Application No: LU/163/20/PL
Site Address: 6 Selborne Place Selborne Road Littlehampton BN17 5NH
Description of works: Demolition of existing conservatory, single storey front & rear extensions & change of use from HMO (Sui Generis) to 5 No. flats (4 net) (C3 Dwelling house). This application affects the character & appearance of the Littlehampton Seafront Conservation Area & may affect the setting of a listed building. This application is not CIL Liable as flats in Zone 4 (Zero Rated).

Thank you for your internet representation made on 27th July 2020 which has been recorded as an objection with the comments as follows:

drawing title
Proposed Plans
-
PLANNING

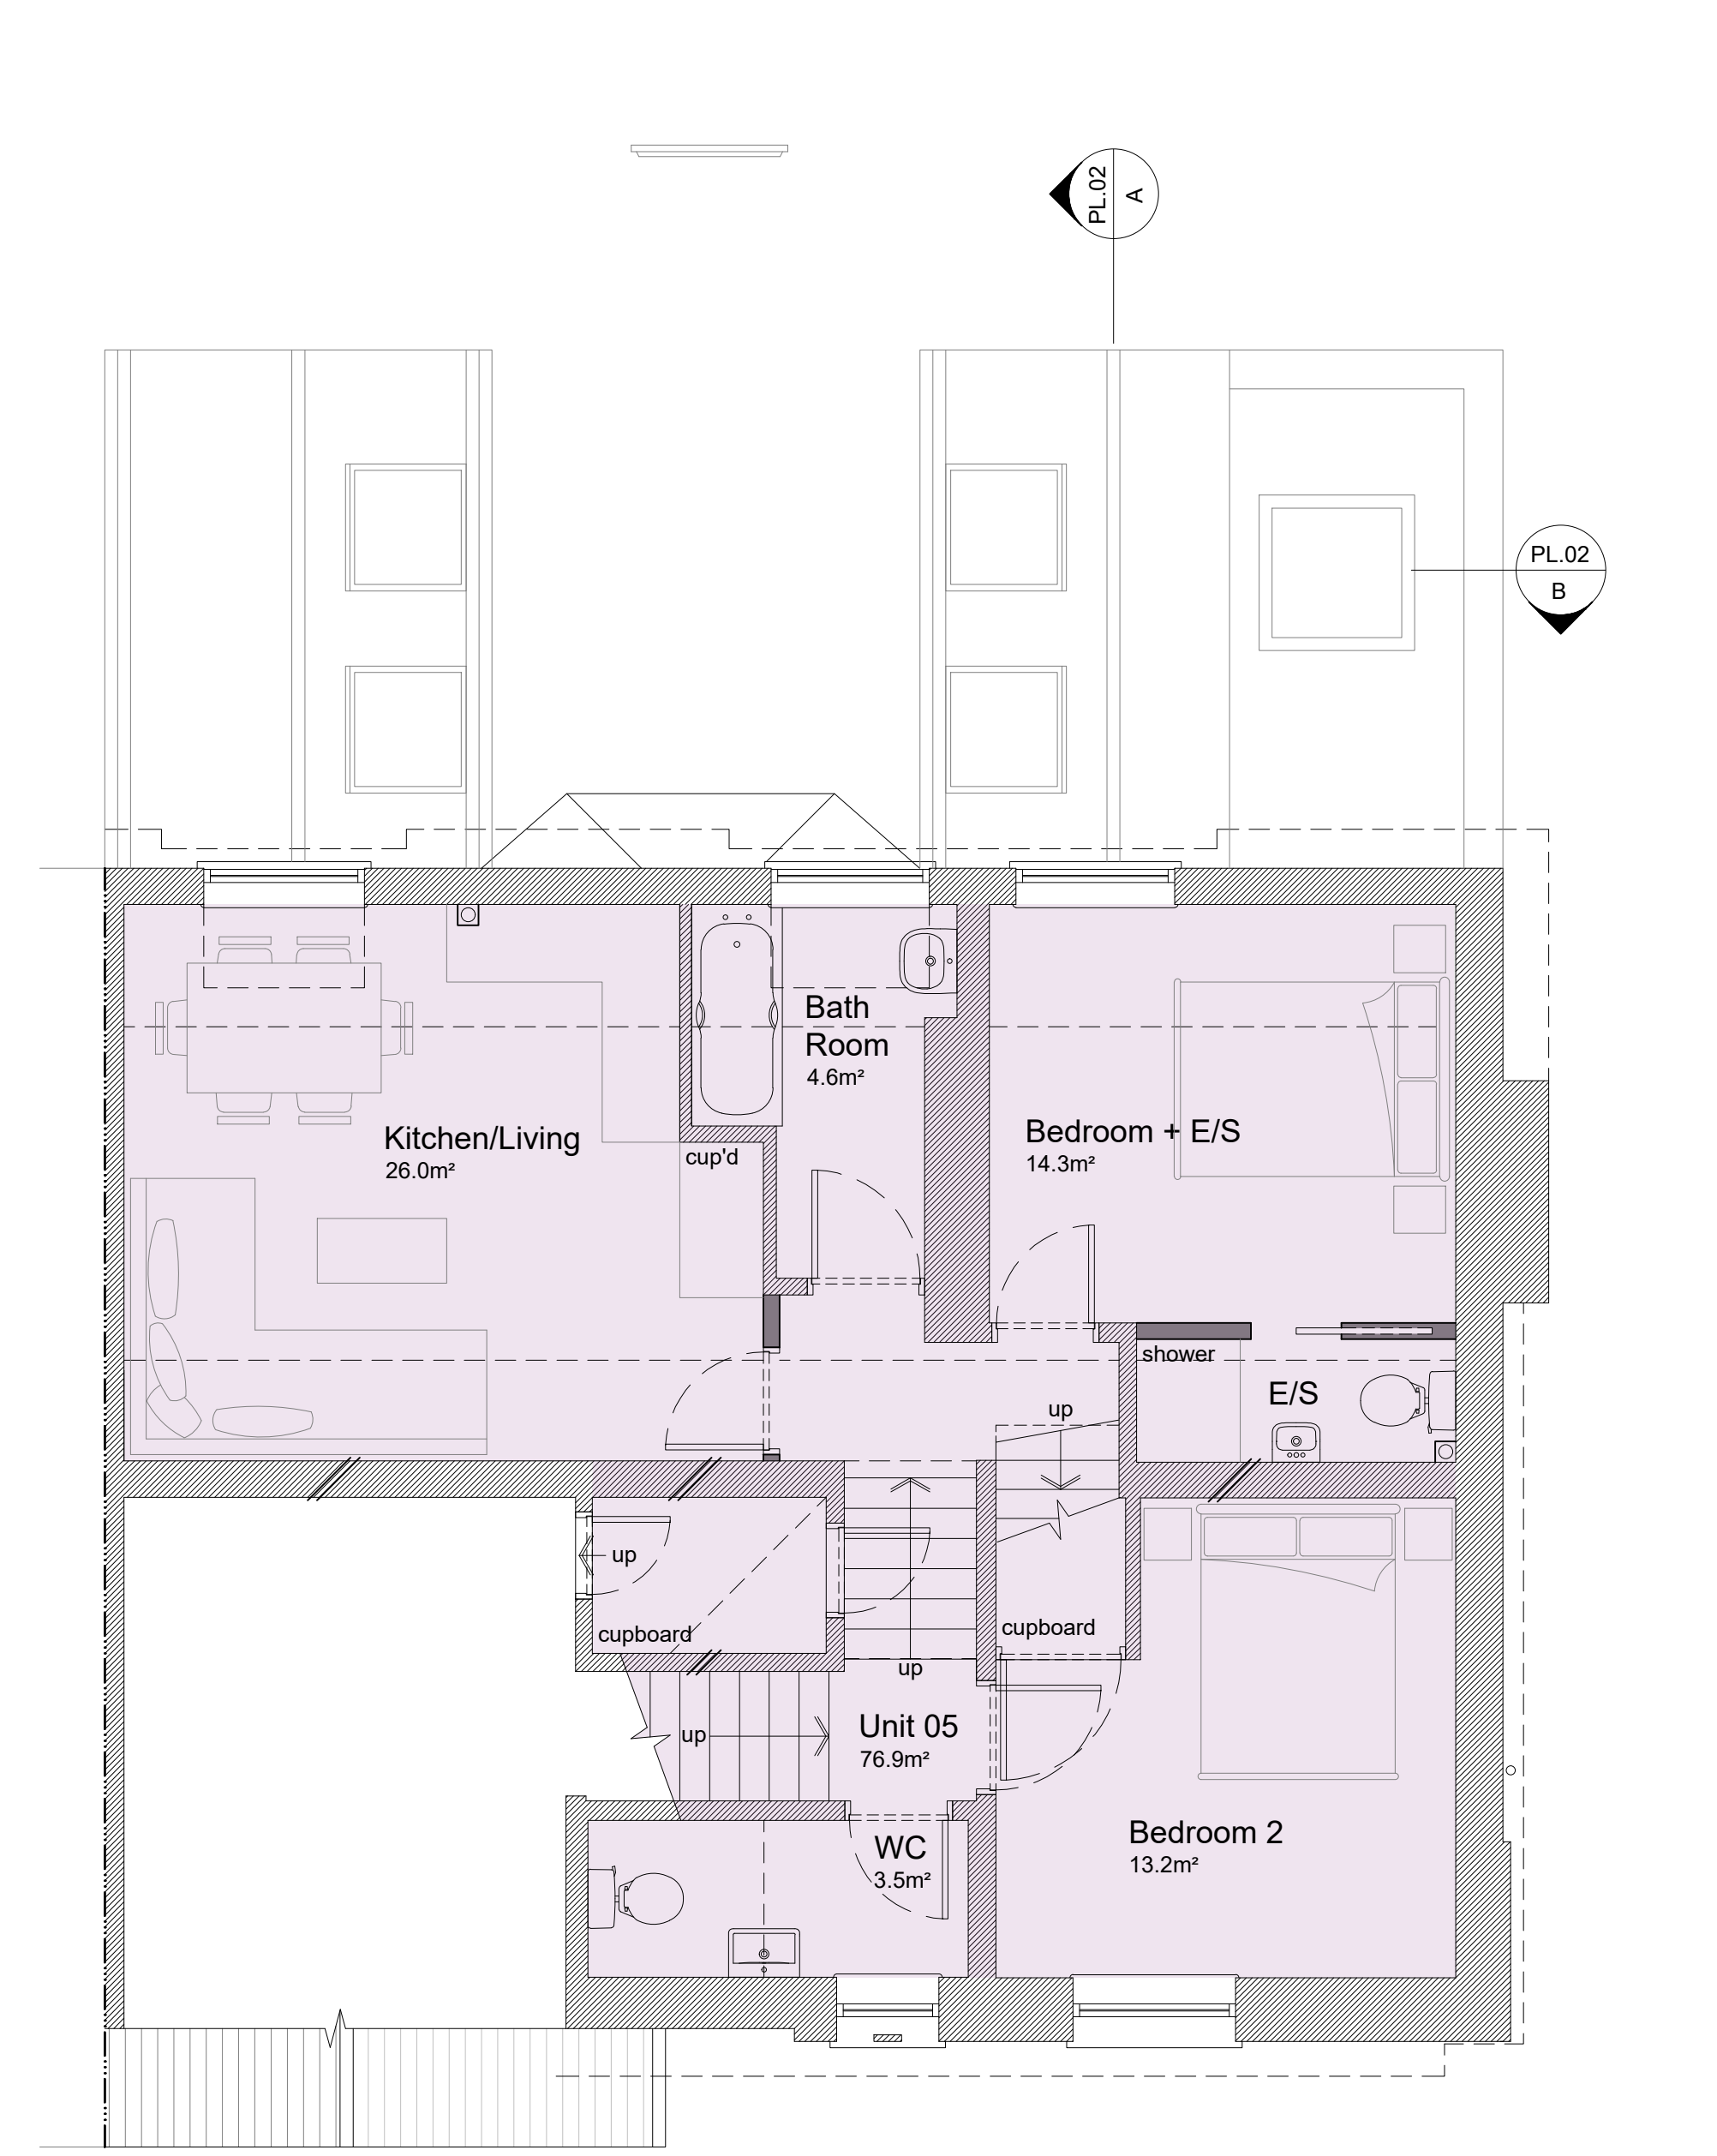
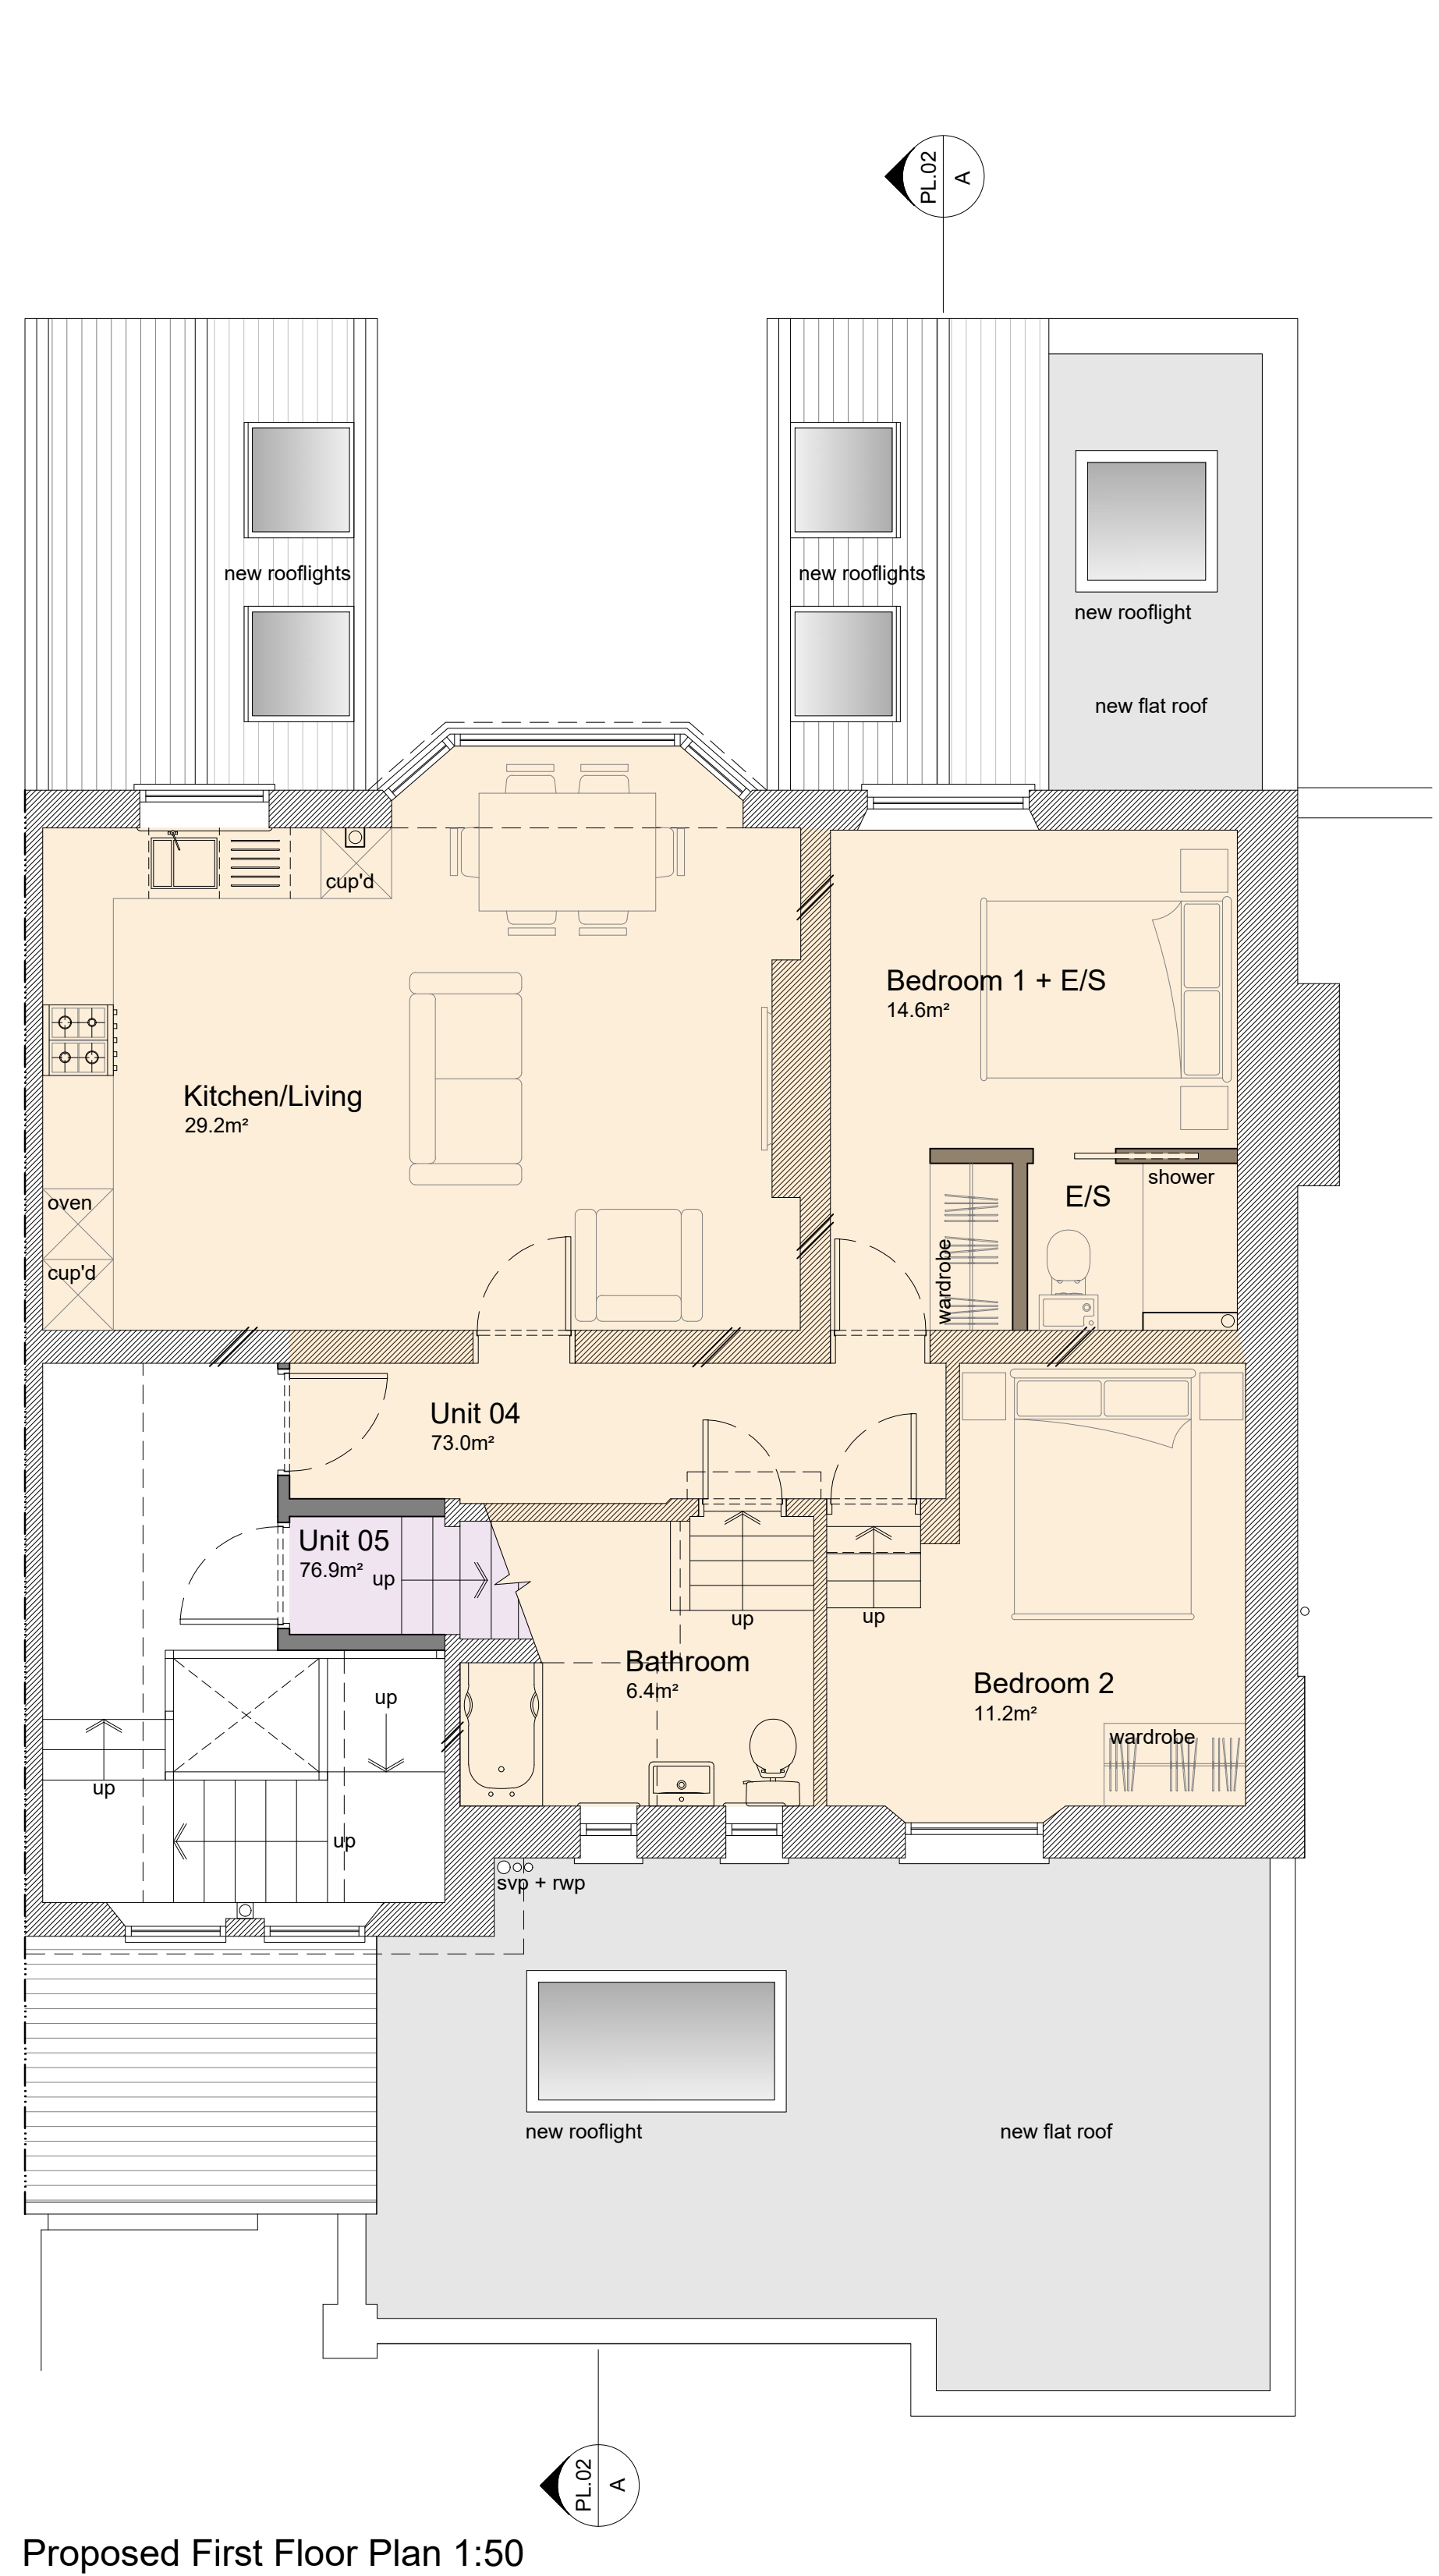
The Town Council's Planning and Transportation Committee considered this matter at its meeting held on Monday 20th July 2020 and objected to the application. Whilst the Committee welcomed the move to convert the premises from an HMO to a better standard of residential accommodation, there were significant concerns that some of the flats did not meet the minimum space standards (Policy DDM2 of the Arun Local Plan). However the Committee did also consider that the proposals were well presented and indicated that if the issues with the room sizes could be satisfactorily addressed they would be willing to reconsider their decision.
